LINDFIELD LEARNING VILLAGE

RESPONSE TO SUBMISSIONS - BUILT HERITAGE

This report has been prepared by Urbis Heritage on behalf of the NSW Department of Education and School Infrastructure NSW (the Applicant). It sets out responses to the agency and public submissions relevant to State Significant Development Application (SSD 16_8114) for Lindfield Learning Village (the site).

Figure 9 – Proposed demolition plan showing removal of the link and planter.

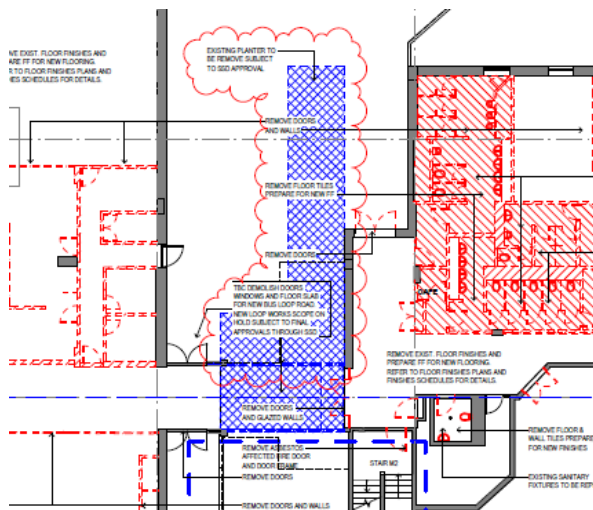
The ground floor of the link between Stages 1 and 5 of the building, graded as moderate significance, is proposed to be demolished to enable the new loop road to pass through to the rear of the building. The bulk of the ground floor section to be demolished comprises large areas of anodised glazing that is attributed little significance in the CMP. The removal of the planter box and service area adjacent to the link removes part of the original landscape design recommended to be retained (Policy 44 CMP) however as a service/courtyard area it is assessed as of lesser significance. The partial demolition of the link would have some heritage impact on the heritage values however it can be supported as the retention of the first floor enables the original configuration to be interpreted and the requires less tree removal than the alternative via the western side of the Stage 5 building.

Noted. Please note however that the option for the extended driveway has been amended (refer Section 3.4) below. The demolition of the link between Stage 1 and 5 is no longer required to accommodate the extended driveway. It is still required to facilitate access by firefighting and emergency vehicles. However, for the reasons outline by the delegate in the agency submission, the heritage impact of the works is assessed to be acceptable.

Figure 20 – Proposed demolition to southern façade.

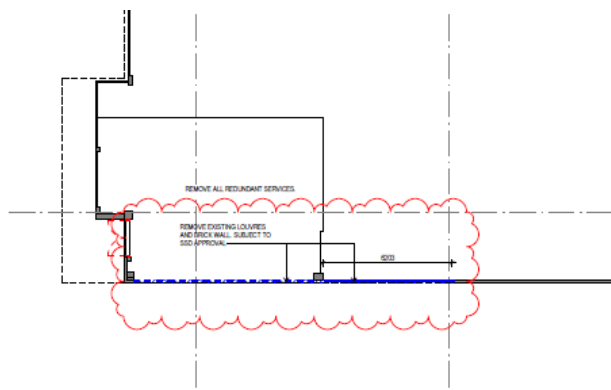
The removal of an area of louvres and a small section of brick wall to the south façade, graded high significance, is proposed. The anodised windows are graded of little significance and as they are not part of a fenestration pattern, their removal is consistent with the CMP fenestration policy. However, the removal of brickwork to slightly enlarge the opening is irreversible and will remove significant fabric.

Urbis Heritage Response:

Figure 23 – Revised SSD proposal showing revised COLA design.

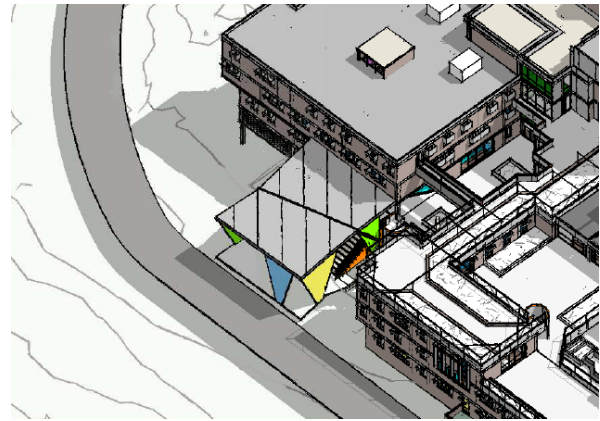
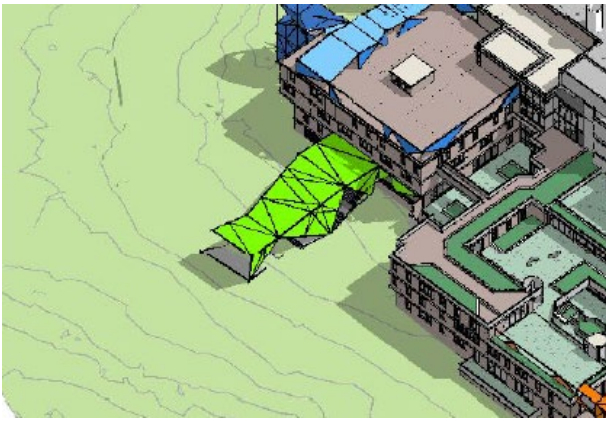
8. Alterations to COLA
